Ribble Valley Borough Council
Council Offices
Church Walk,
Clitheroe
Lancashire
BB7 2RA

Phone: 0300 123 6780
Email: Kathryn.Walsh@lancashire.gov.uk
Your ref: 3/2024/1020
Our ref: 3/2024/1020/HDC/KW
Date: 12 February 2025

Location: St Cecillas RC High School Chapel Hill Longridge PR3 2XA
Proposal: Proposed enlargement of Car Park B to create 15 additional designated parking bays; Remove planting bed adjacent to existing disabled parking bay to provide two side-by-side disabled parking bays; Provision of three new cycle shelters, providing space for 18 bicycles along the main school entrance walkway.
Grid Ref: 360264 436679

Project	
St Cecilia's RC High School Longridge	
Title	
Proposed Parking Plan	
Scale	1:200 @ A3
Date	20.11.24
Drwg No	4974 /P04
Drawn

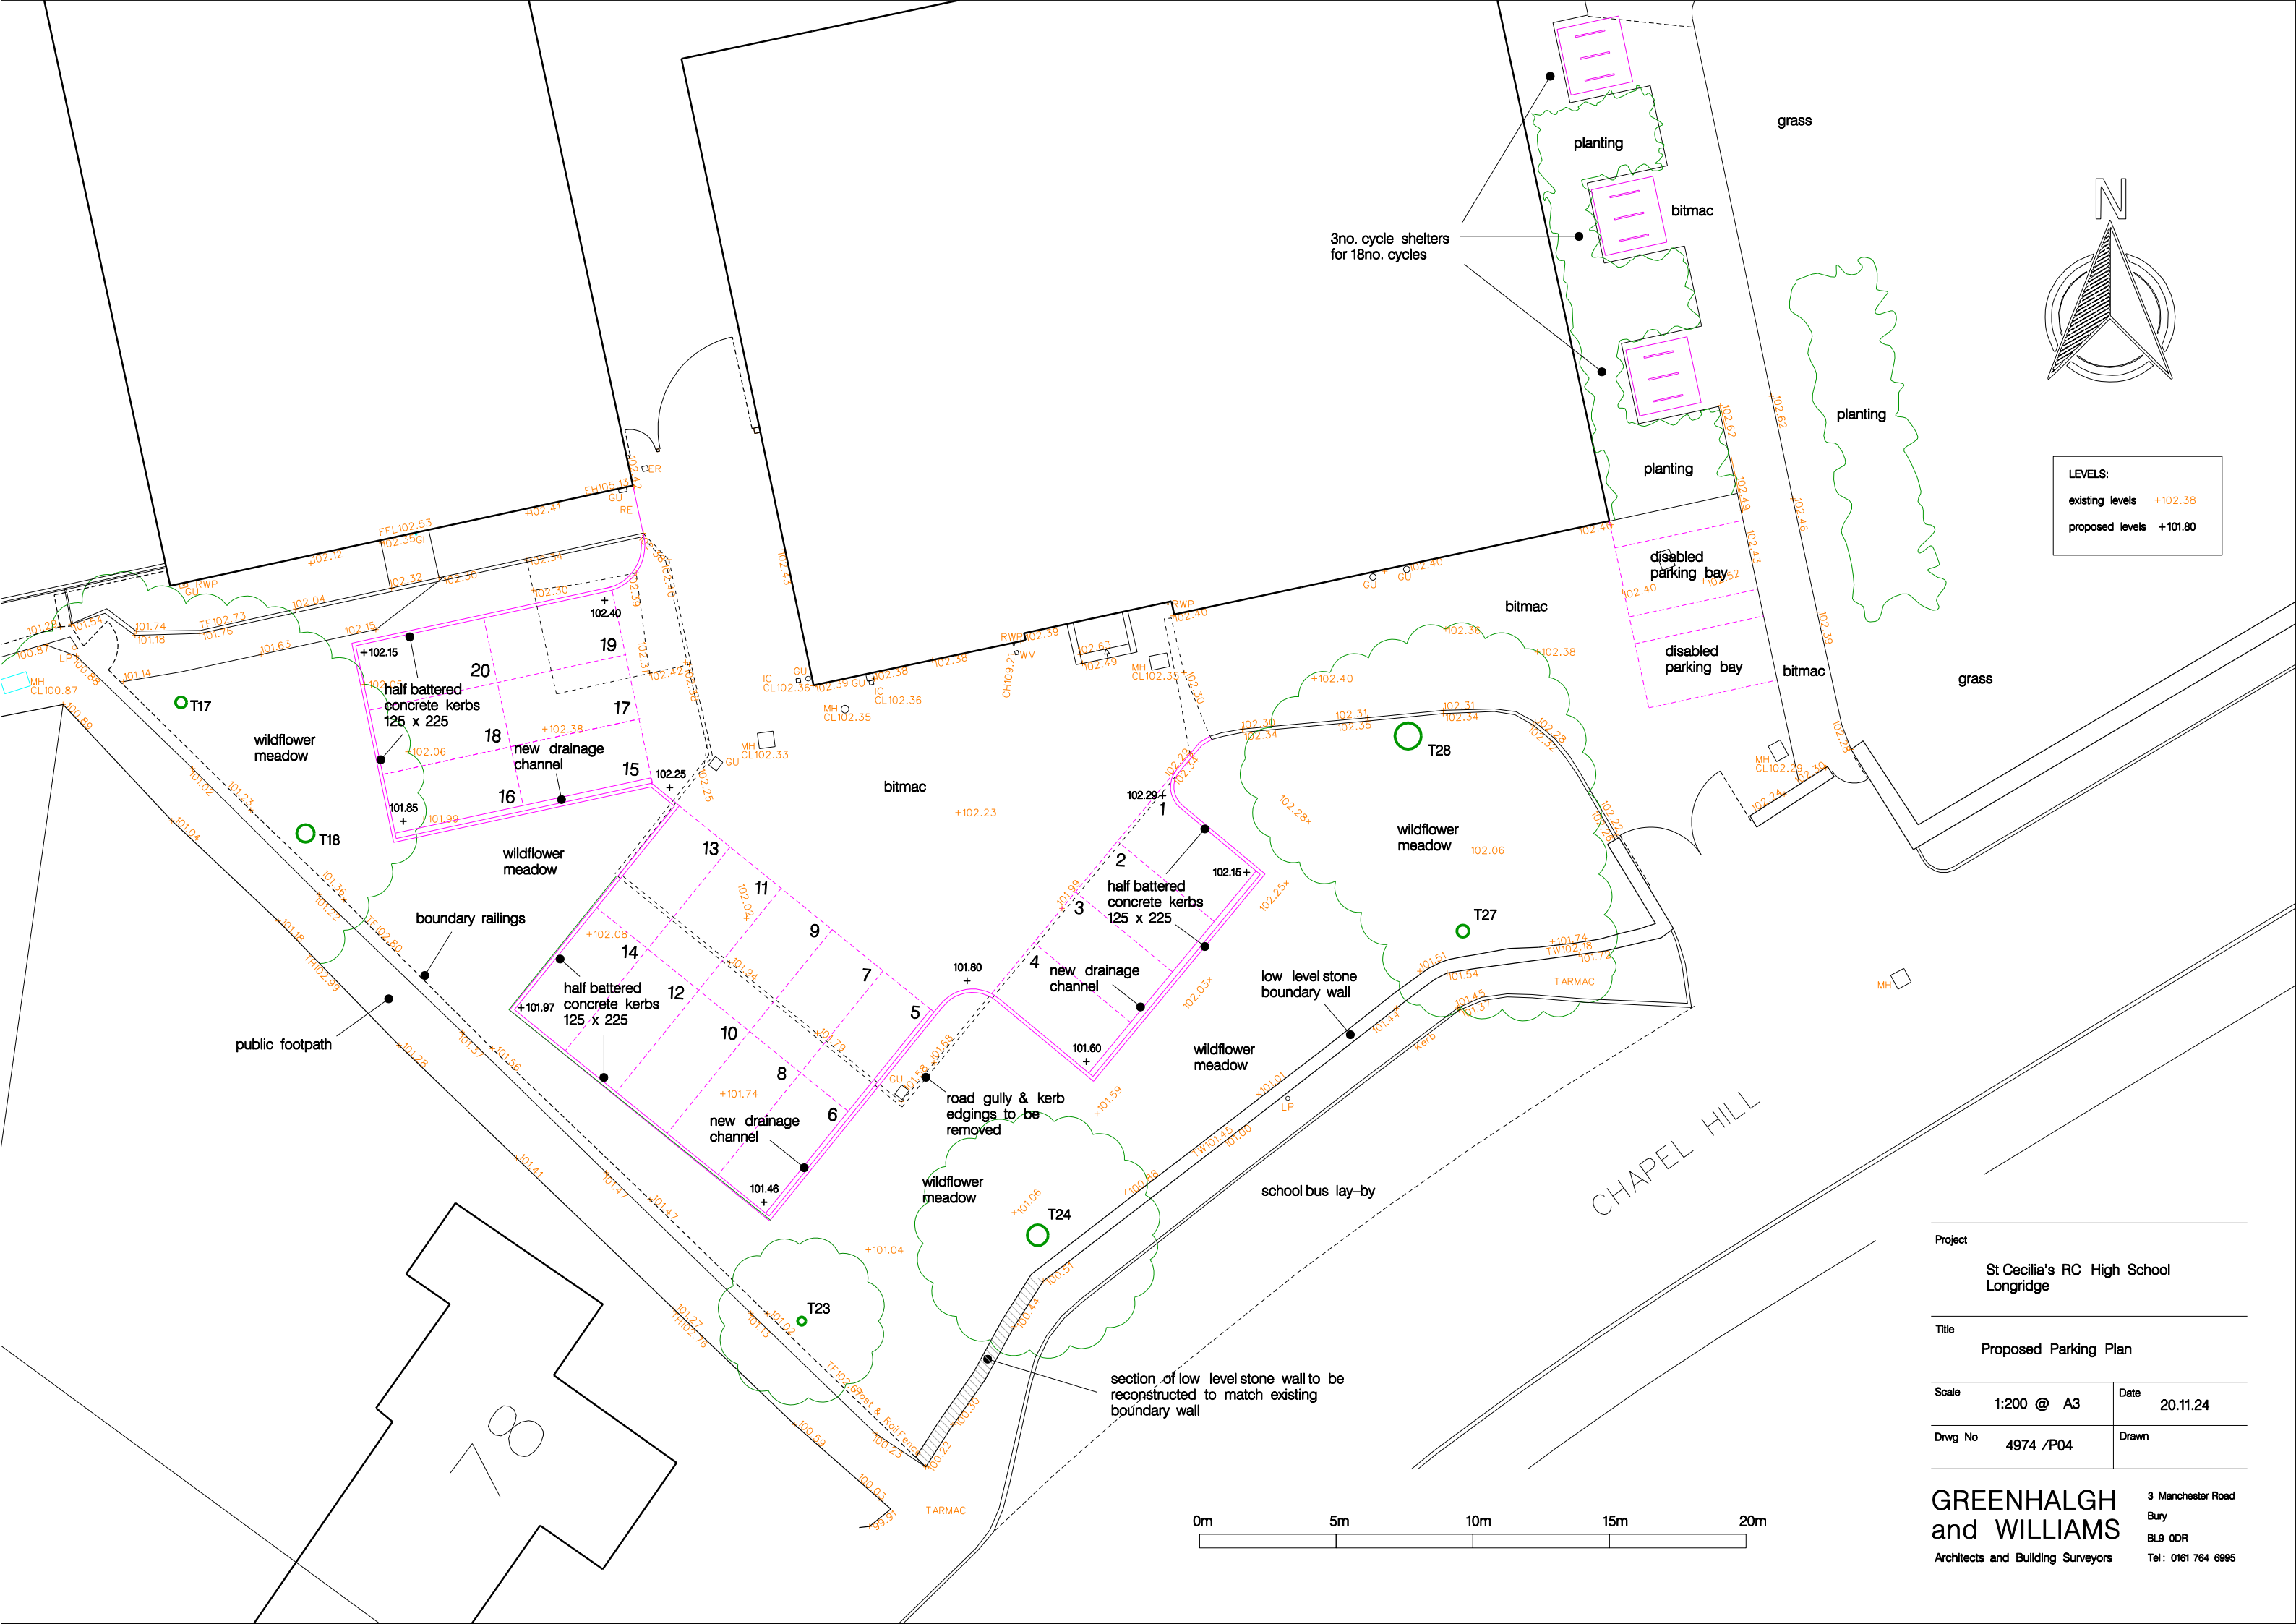
The proposal will result in the expand car parking B to create 15 additional designated parking bays, resulting in a total of 20 parking bays alongside one new Disabled Parking Bay next to the existing Disabled Parking Bay. The development will result in a total off street parking provision of 40 standard parking bays and 2 Disabled Parking Bays.

1. The car parking and turning areas shown on the approved plan shall be provided in full and are available for use. The car parking and turning areas shall thereafter be kept available for the parking and manoeuvring of vehicles at all times.
Reason: To improve the provision of adequate car parking on site and in the interests of highway safety.
